Submission: Application no. SSD-93020230

40-48 Redan Street Mosman

Residential Development with In-fill Affordable Housing

Summary

Figure 14 Traffic volumes along Melaleuca Lane

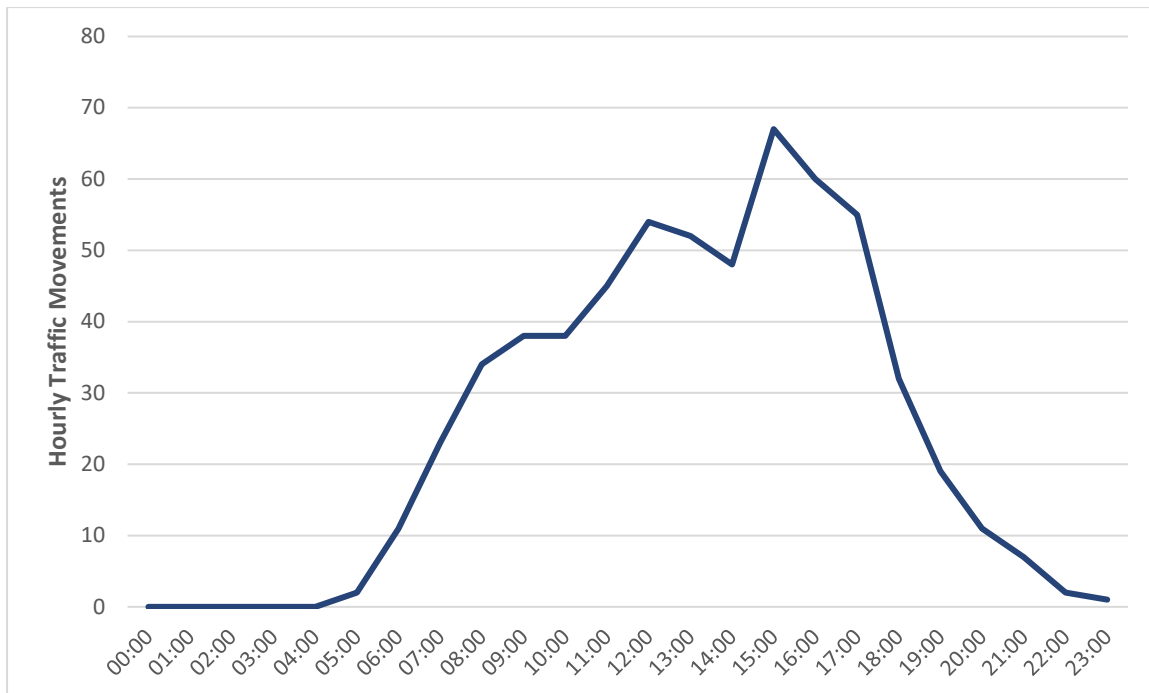
The first fundamental issue with both walking routes 1 and 2 is that they propose a crossing of Almora Street at locations which are easily demonstrated to be unsafe and inconsistent with the 'walking distance' definition.

Crossing Almora Street at these locations is unsafe, including because:

- The crossings shown involve no kerb ramp and require pedestrians to cross a busy two-lane road at an unmarked location.
- Almora Street curves down from Military Road, with poor line of sight for drivers approaching the crossing points. The double unbroken lines are consistent with that safety concern.

- If the 48-50 Almora Street development application proceeds as proposed, there will be an additional hazard created by vehicles entering and exiting that site near the proposed crossing point, particularly in relation to Route 2.
- Page 15 of the Transport Impact Assessment lodged with the 48-50 Almora Street DA refers to a previous moderate injury collision between a car and a pedestrian crossing at the same location as the Route 1 crossing.
- In addition to motor vehicles, there are designated bike lanes on each side of Almora Street running from the intersection with Military Road, adding the risk of bike-pedestrian collisions.
